**KIRKLEES METROPOLITAN COUNCIL
INVESTMENT & REGENERATION SERVICE**

DELEGATED DECISION TO DETERMINE PLANNING APPLICATIONS

Reference No:	2024/62/90304/E
Site Address:	146, Denby Lane, Upper Denby, Huddersfield, HD8 8UN
Description:	Erection of single storey rear extension (within a Conservation Area)
Recommending Officer:	Nicole Helliwell

DECISION - REFUSED

DRAWING TITLE
GA DRAWING

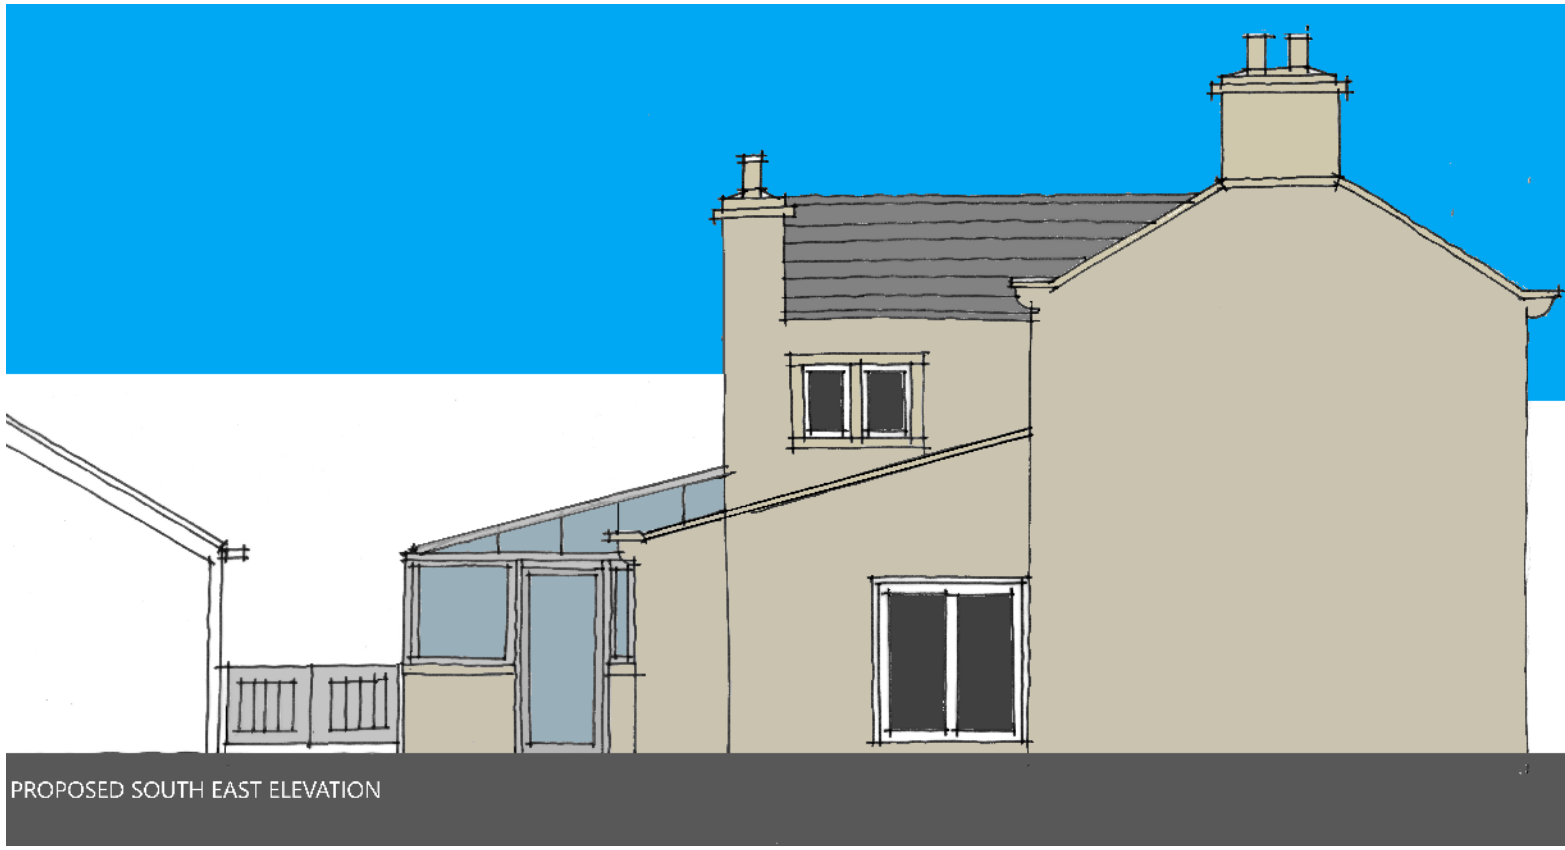
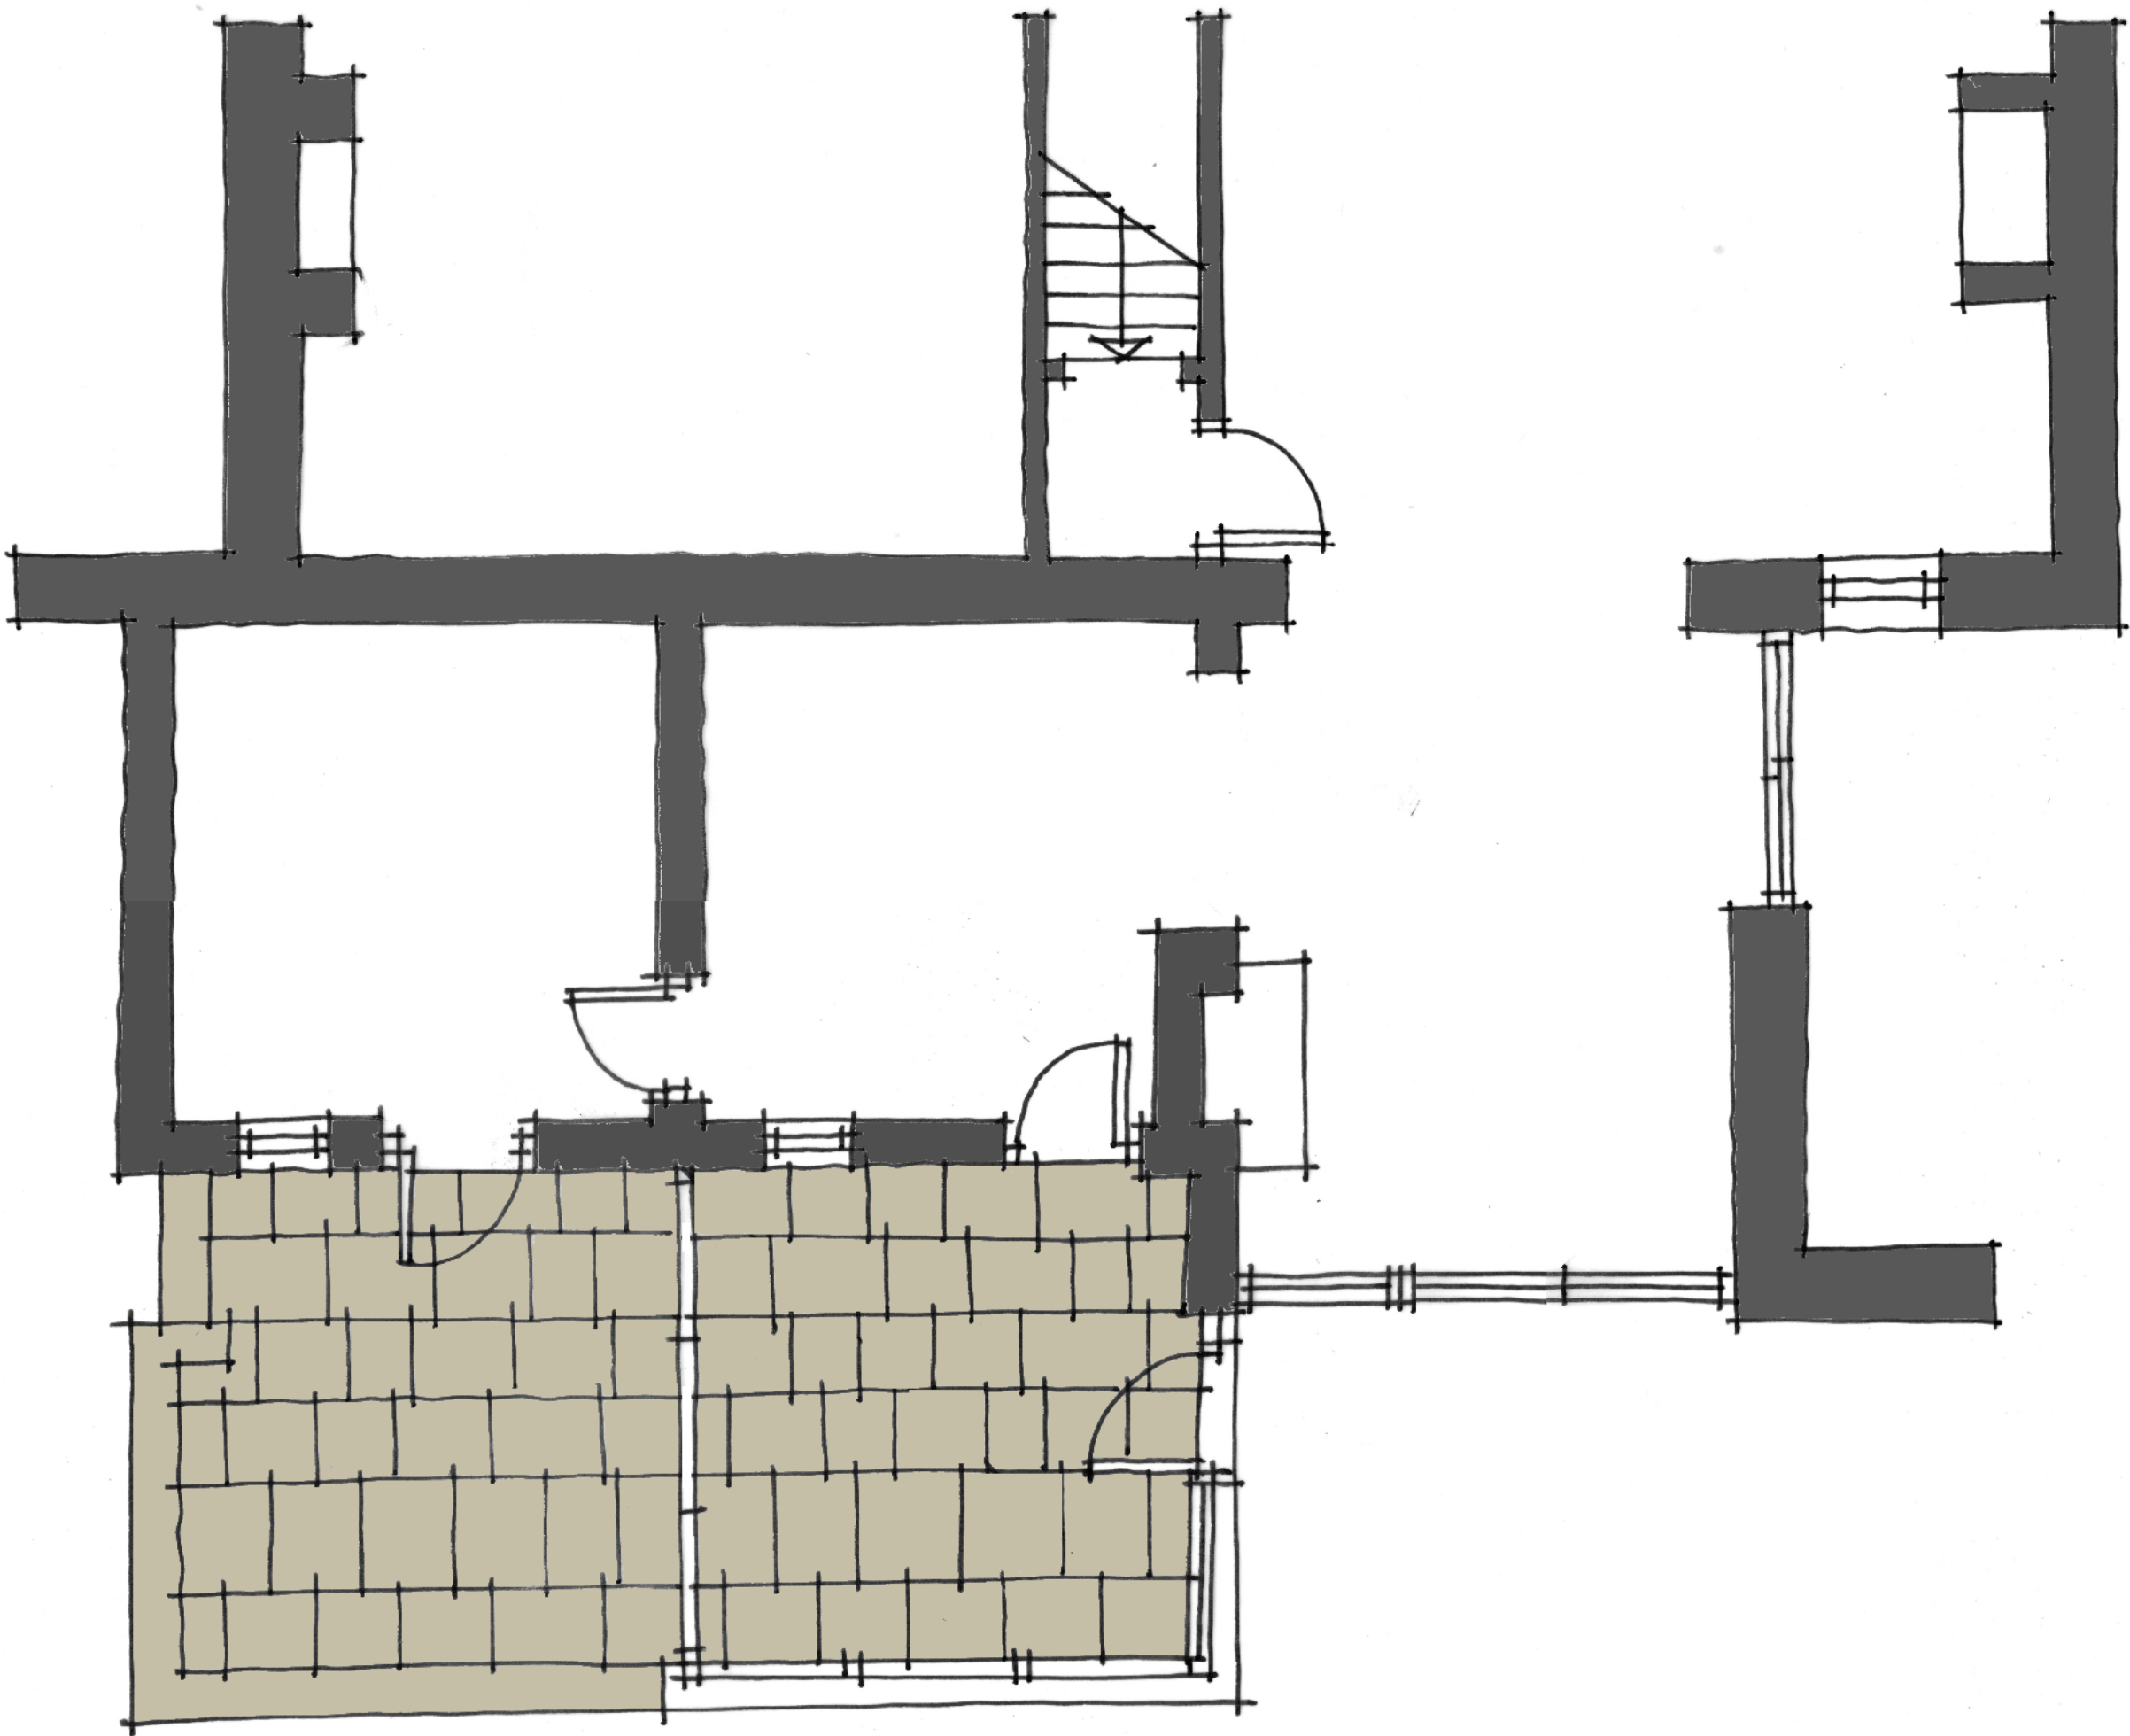
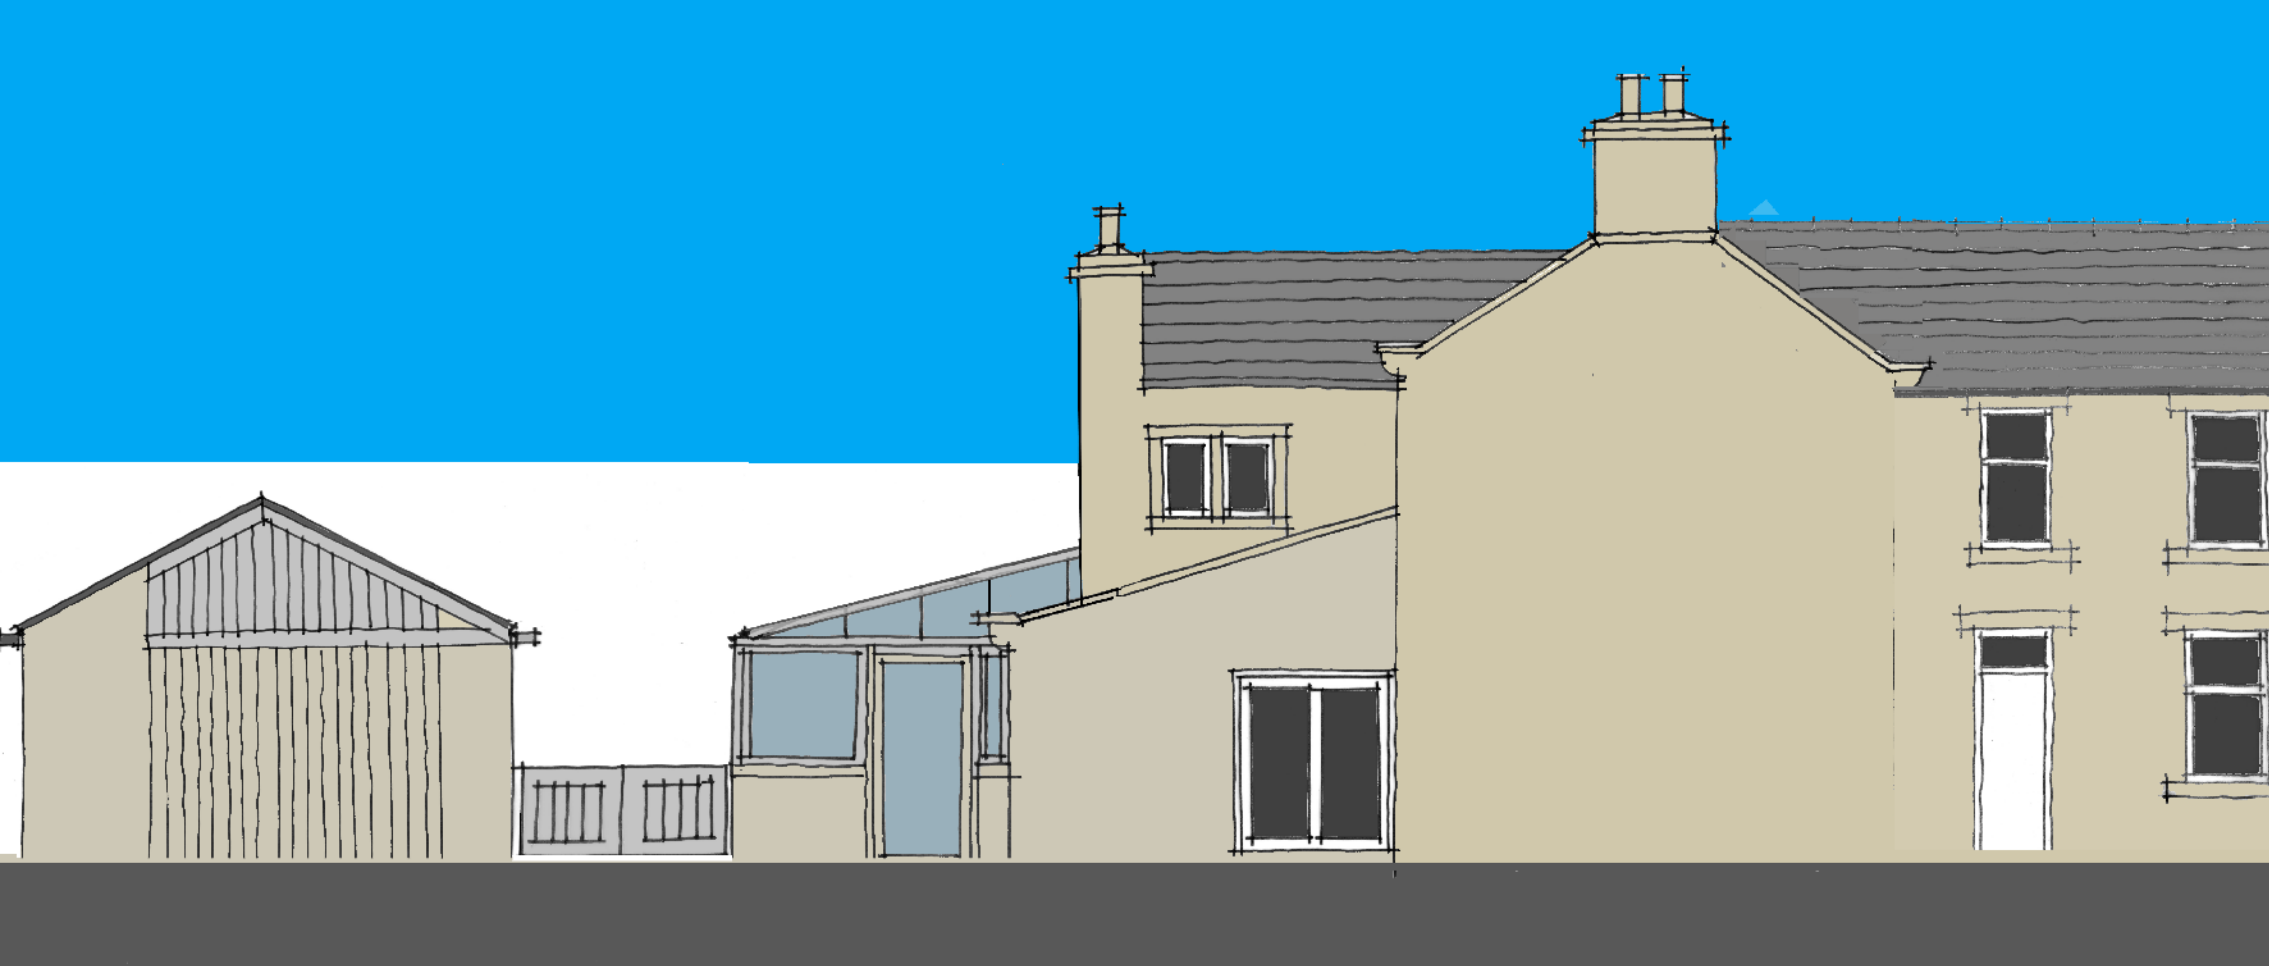
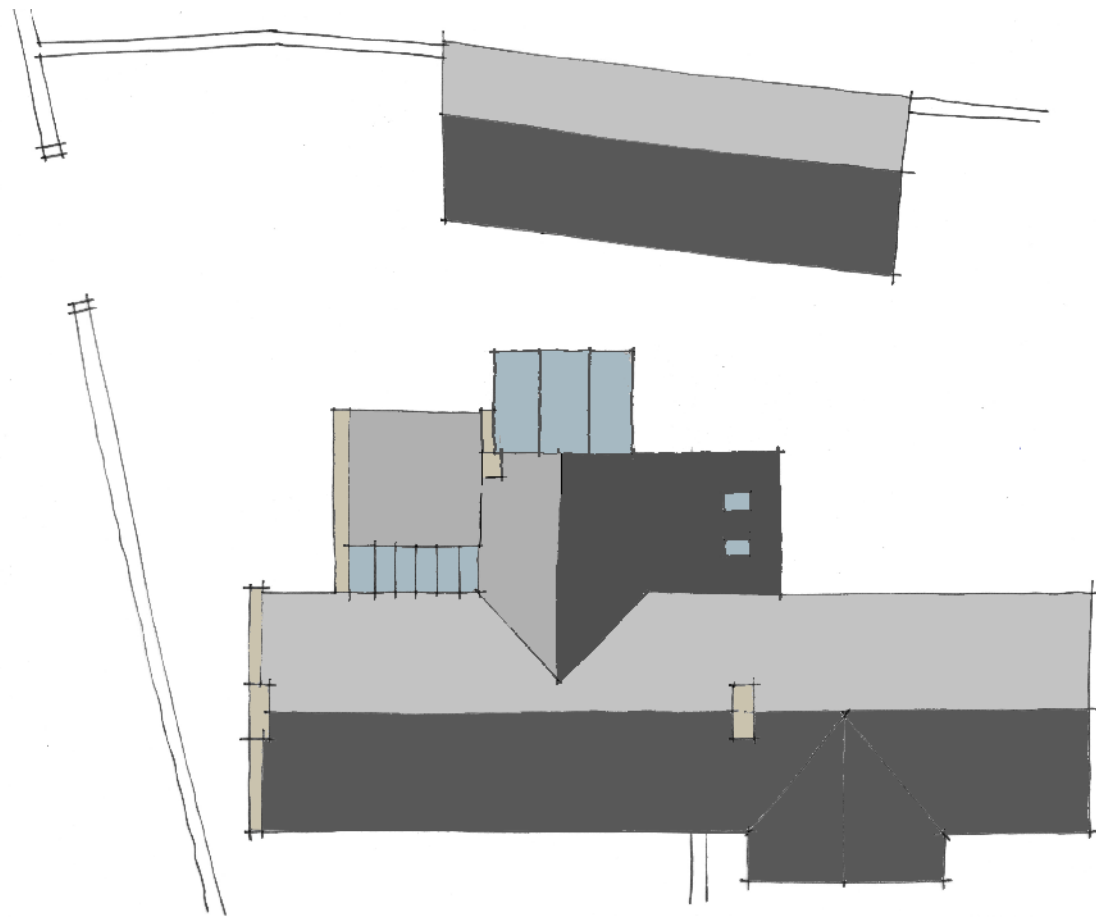
The proposed single storey extension would project approximately 4m from the rear elevation of the original dwellinghouse. Although the extension would be partly faced in natural stone to match the appearance of the host property, it would have a contemporary appearance due to it being heavily glazed. As such, it is considered that the design and material palette would be unsympathetic to the character of the surrounding area. Furthermore, due to its location and scale, the enlargement would appear unduly prominent within the curtilage of the house and would be highly visible from public vantage points along Denby Lane. On this basis, the proposed development would represent a poorly designed addition which would detract from the character of the host property and the Upper Denby Conservation Area. Furthermore, there are also no public benefits to outweigh the less than substantial harm to the setting and character of the building as a non-designated heritage asset and the Conservation Area.

On this basis, it is considered that the proposal would detract from the character and appearance of the non-designated heritage asset and the Upper Denby Conservation Area and would fail to accord with Policy LP24 of the Kirklees Local Plan, KDP 1 & 2 of the House Extensions and Alterations Supplementary Planning Document and the aims of Chapter 12 of the National Planning Policy Framework. Furthermore, the proposed development would cause less than substantial harm to the setting and character of the Upper Denby Conservation Area and would fail to accord

3 Upper House Fold is a residential property located north of the application site. Whilst it is noted that the corner of the proposed enlargement would protrude past the 45-degree angle measured from the midpoint of the neighbour's ground floor fenestration, it is taken into account that the existing rear extension currently fails to accord with the 45 degree rule. On this basis, it is considered that the proposed development would not result in any further harm to the neighbour's residential amenity over the existing.

The proposed single storey rear extension by reason of its location, scale, materials and design would detrimentally harm the historic character of this period property and the Upper Denby Conservation Area. There are also no public benefits to outweigh the less than substantial harm to the setting and character of the building as a non-designated heritage asset and the Conservation Area. The proposal is therefore contrary to the aims of Policies LP24 and LP35 of the Kirklees Local Plan and Chapters 12 and 16 of the National Planning Policy Framework.
